Historic England

WRITTEN REPRESENTATIONS

Dogger Bank South Offshore Wind Farm Projects (Reference No.

Application by

OS reference: 503705 E 439231 N
 AOD (Above Ordnance Datum): 27.51 m
 Direction of view: 222°
 Horizontal field of view: 90° (cylindrical projection)

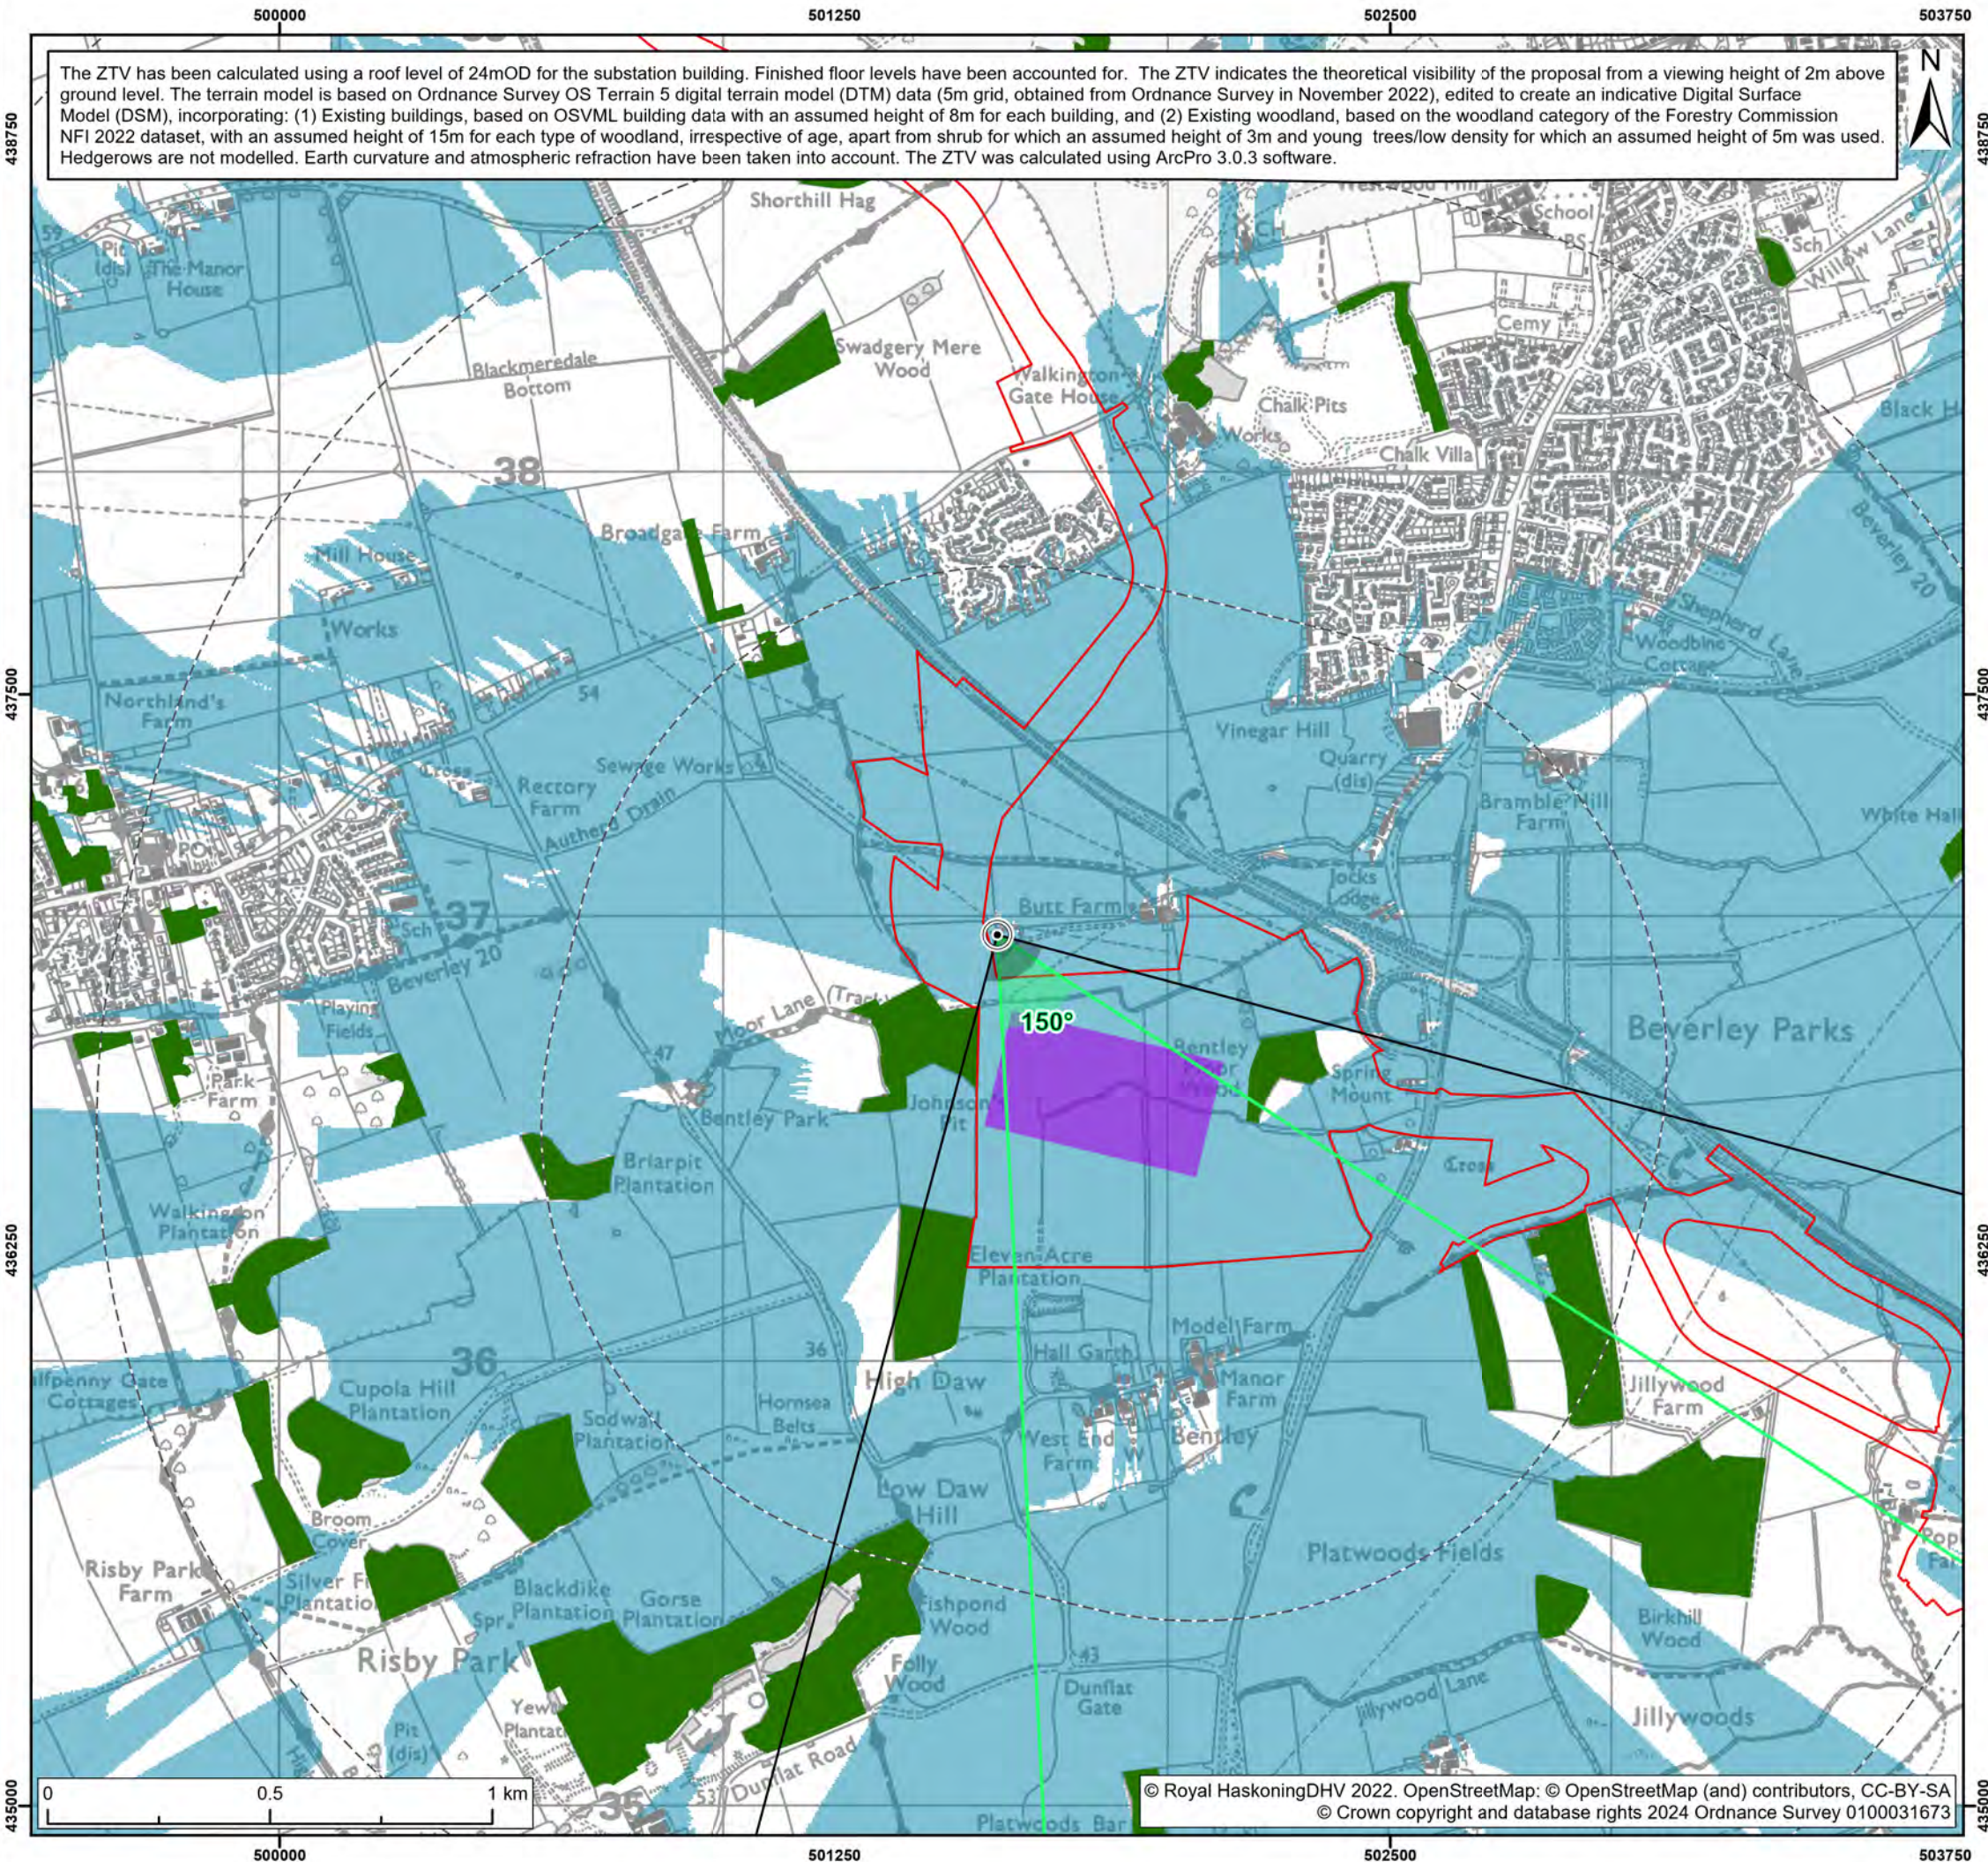
- 4.5 The Project Change Request proposes the reduction in size of the footprint of the proposed OCS, previously depicted as a visualisation ([APP-192] for Landscape and Visual text, para 23.6.2.3.1 onwards, and [APP-193] Fig 23-15a2; [APP-193] Fig 23-15a3). These visualisations presented a 'worst case scenario' (two Onshore Converter Stations within the Converter Station Area) and indicated the scale and massing of one possible product of the scheme, as seen from the nationally important Scheduled Monument of 'Heavy Anti-aircraft Gunsite, 350m west of Butt Farm', NHLE 1019186 (the "Butt Farm Gunsite").

- 4.7 The extent, massing, scale of the proposed OCS structure and its proximity to the Scheduled Monument represented a considerable concern for Historic England. We considered that the proposed Converter Station(s) represented 'less than substantial harm' to the significance of the site, but at the high end of this scale, owing to the manner in which the experience of being on the scheduled site would be diminished by the over-bearing presence and scale of the Converter Station(s). The proposed Converter Station(s) would significantly reduce the open quality of the landscape setting of the scheduled monument, and hinder understanding of its wartime use.

- 4.8 Following the change request, it is now proposed that the footprint of the OCS is to be reduced in scale. We note and welcome the reduction in the size of the footprint and agree that the proposed reduction in scale of the OCS will lead to a reduced potential for effects on buried archaeology and a reduced visual impact when seen from the Butt Farm Gunsite. However, we consider that the harm to the significance of the designated site will remain at 'major adverse', and not 'minor adverse' as suggested by the Applicants. This high degree of 'harm' needs to be addressed. This can be achieved by reducing the impact of the building, or finding ways to mitigate the harm it would cause. We do not consider that screening through planting is an effective or lasting mitigation measure in this instance and have referred to this in our response to the ExA's questions of 10th January 2025 (Question ISH 2.10.12).

- 4.9 It is clear from the supporting text in the Environmental Statement ([APP-192], para 91, page 69) and the Project Change Request that the design component of the OCS is a work in progress. The Project Change proposals have not been confirmed, whilst [APP-192], para 93, page 69 states that the Environmental

Statement visualisation does ‘not show details of finishes or colours...’. The Applicants have yet to provide a visualisation of the Converter Station at night showing the impact of any service or security lighting.

- 4.10 Therefore, it is not yet possible to understand the full impact of the built element of the scheme on the setting and significance of the scheduled Butt Farm Gunsite. To address this aspect of the proposed development the maximum height, footprint, landscaping scheme and precise location of the Converter Station is to be fixed at DCO stage. If DCO is granted the final details will need to be carefully assessed as part of any post-consent determination.
